**Dogger Bank South Offshore
Wind Farms**

**Marine Management Organisation – Statement of
Common Ground Update**

Document Date: December 2025

Document Reference: 22.6

AN ERM GROUP COMPANY

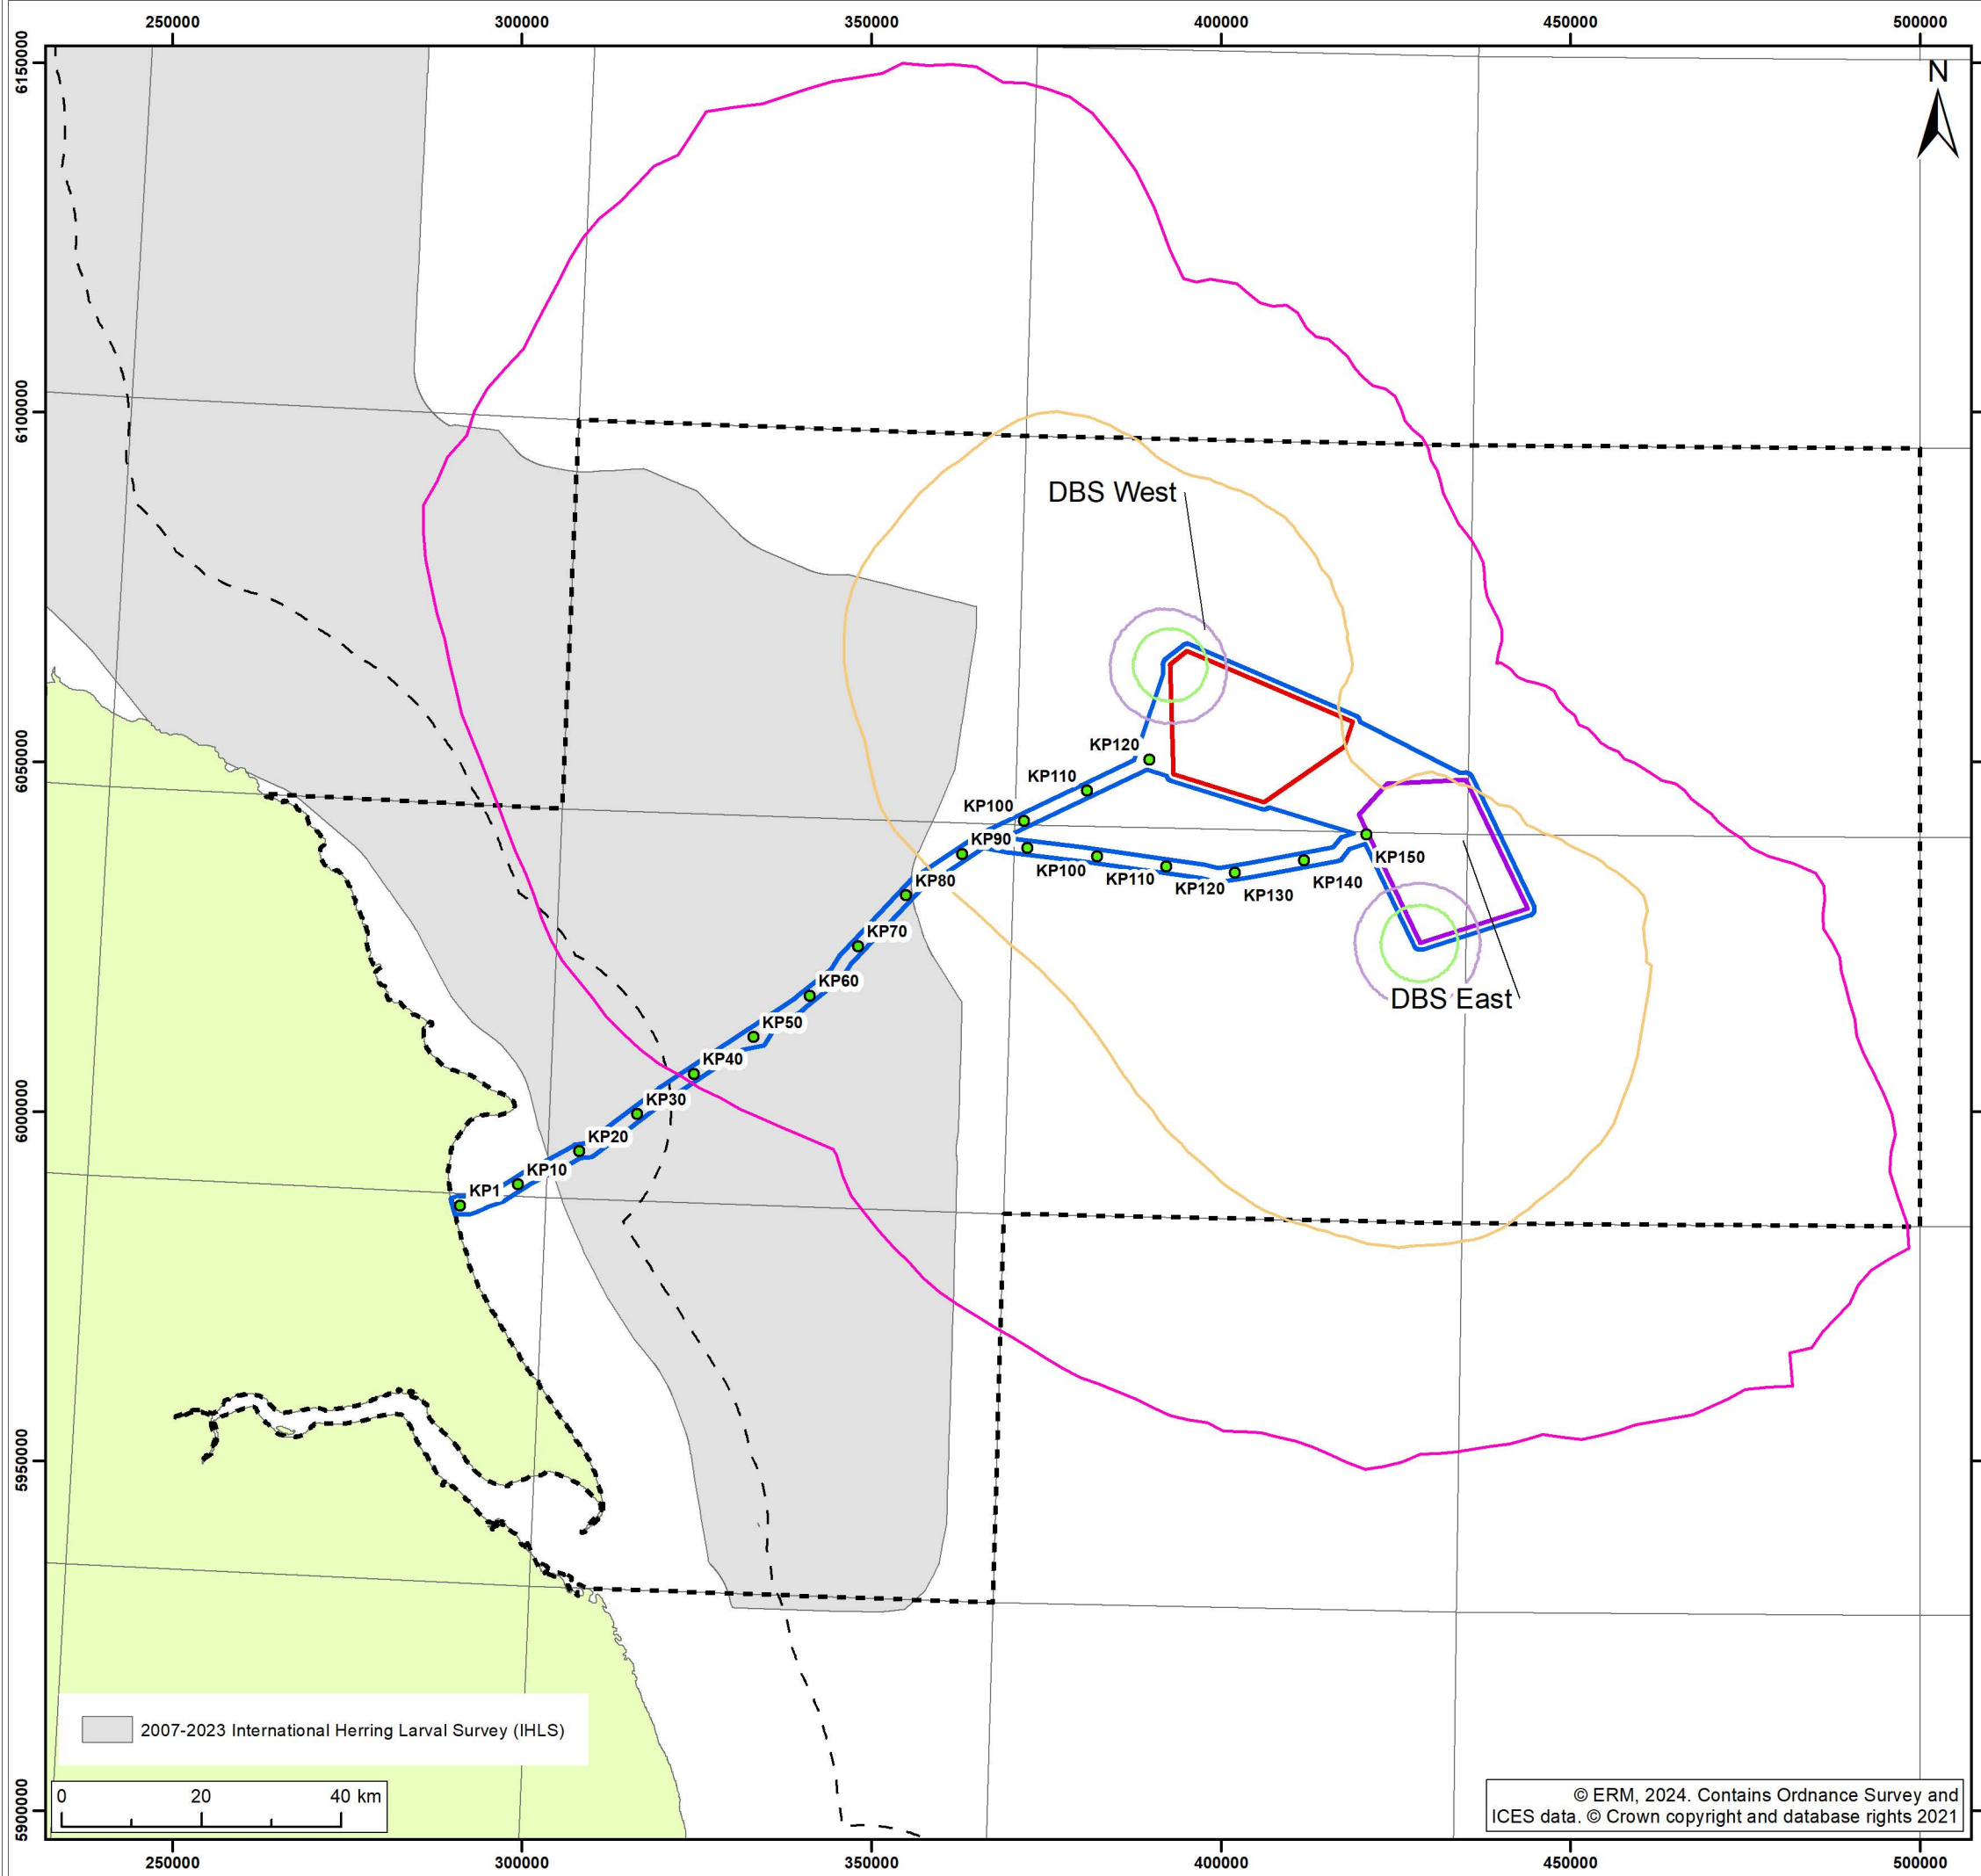
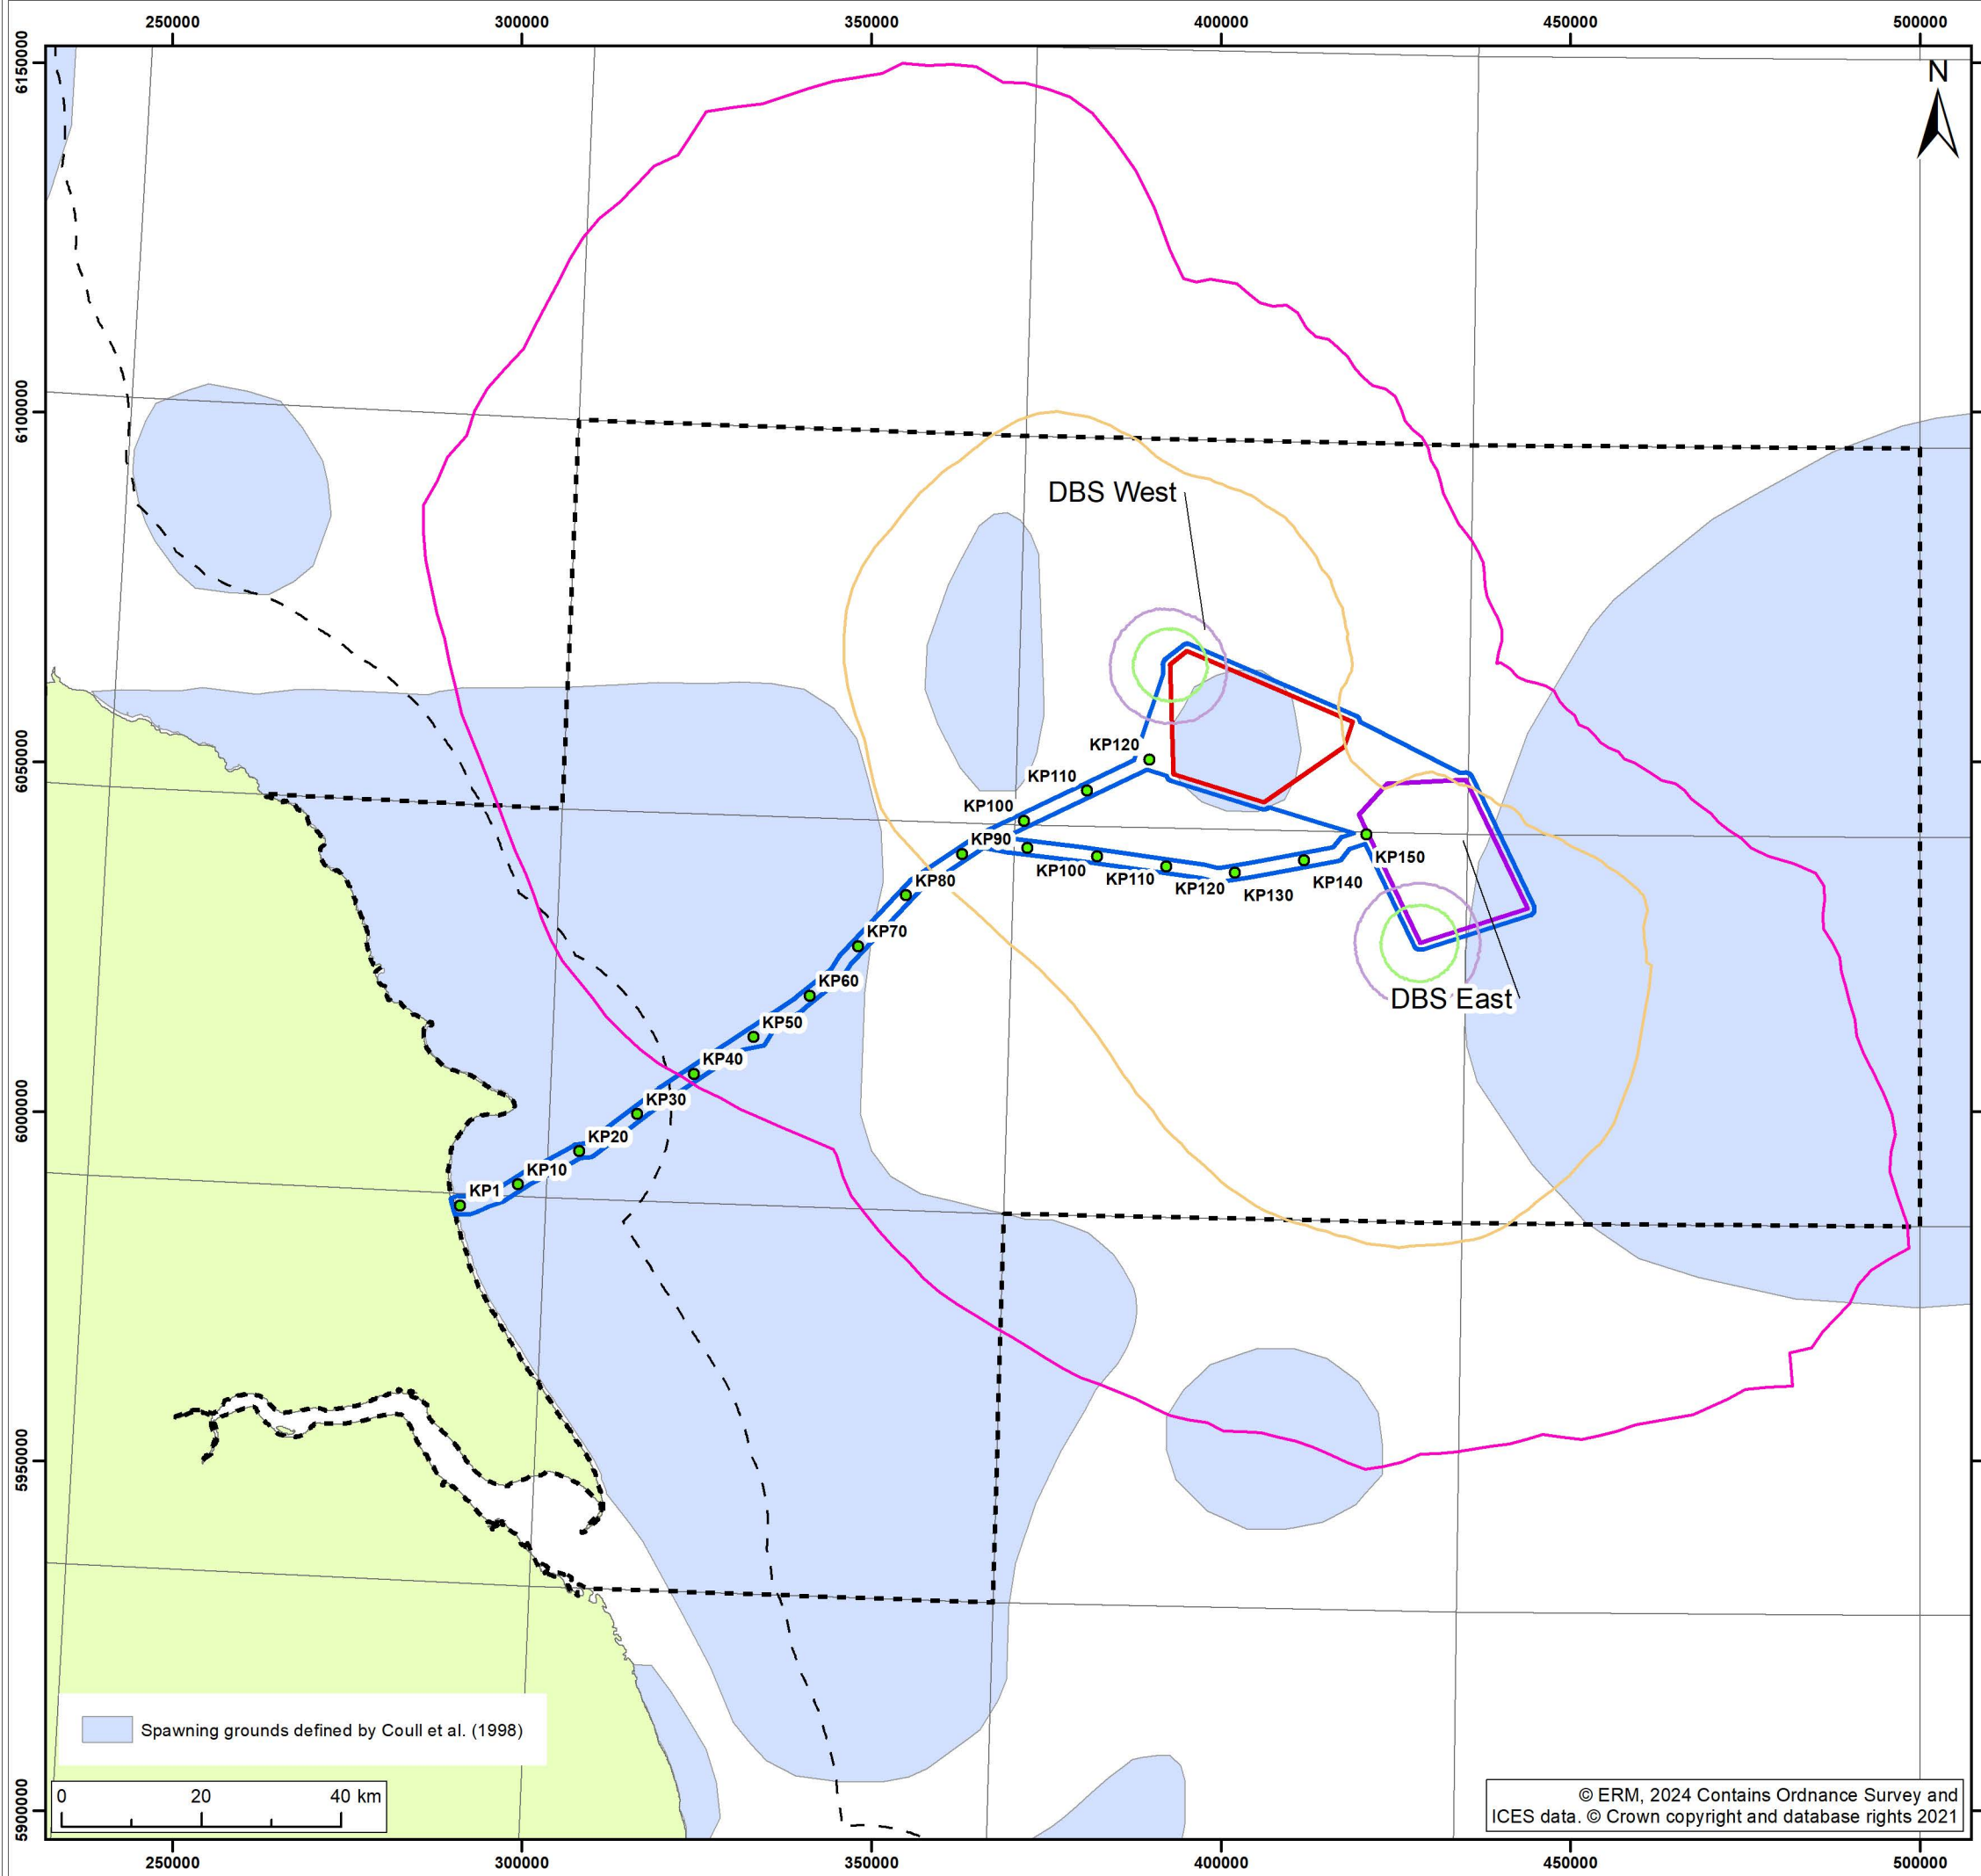
69	<p>The impact assessment methodologies used for the EIA, as presented in section 10.4.3 of Chapter 10 Fish and Shellfish Ecology [APP-091], provide an appropriate approach to assessing potential impacts of the Projects.</p>	<p>1. The MMO requests that the Applicants revises their potential herring spawning habitat and potential sandeel habitat 'heat' maps preferably using the updated version of the MarineSpace methodologies.</p>

SoCG ID	The Applicants' Position	MMO's Position	Position Status
	<ol style="list-style-type: none"> The heat mapping methodology has been updated using the latest MarineSpace guidance within the Heat Mapping Report: Atlantic Herring and Sandeel [AS-105], submitted 28th November 2024. The Applicants acknowledged the MMO's position in The Applicant's Responses to Written Representations [REP2-057] (REP1-074:2.4) but would welcome any comments at the earliest opportunity. The Applicants provided a response in The Applicants' Responses to Deadline 2 Documents [REP3-028] (REP2-061:24). In addition, figures presenting the IHLS data were provided in Appendix A (Figures 2-1 to 2-4 and Figures 3-1 to 3-4) of The Applicants' Responses to Deadline 2 Documents [REP3-028]. The Applicants acknowledge the MMO's comment. During a meeting with the MMO and Cefas on the 15th May 2025, it was confirmed that the additional figures supplied in Appendix A (Figures 2-1 to 2-4 and Figures 3-1 to 3-4) of The Applicants' Responses to Deadline 2 Documents [REP3-028] were sufficient. The Applicants consider this matter closed out. 	<ol style="list-style-type: none"> The MMO stated in the Deadline 1 submission [REP1-074] that they would provide a response to comments relating to Fisheries and Shellfish at Deadline 2 or 3. The MMO provided comments on Fish and Shellfish at Deadline 2 [REP2-061] but queried that the Applicants are missing some key data in the Heat Mapping Report Atlantic Herring and Sandeel [AS-105]. The MMO is content with the heat maps provided.
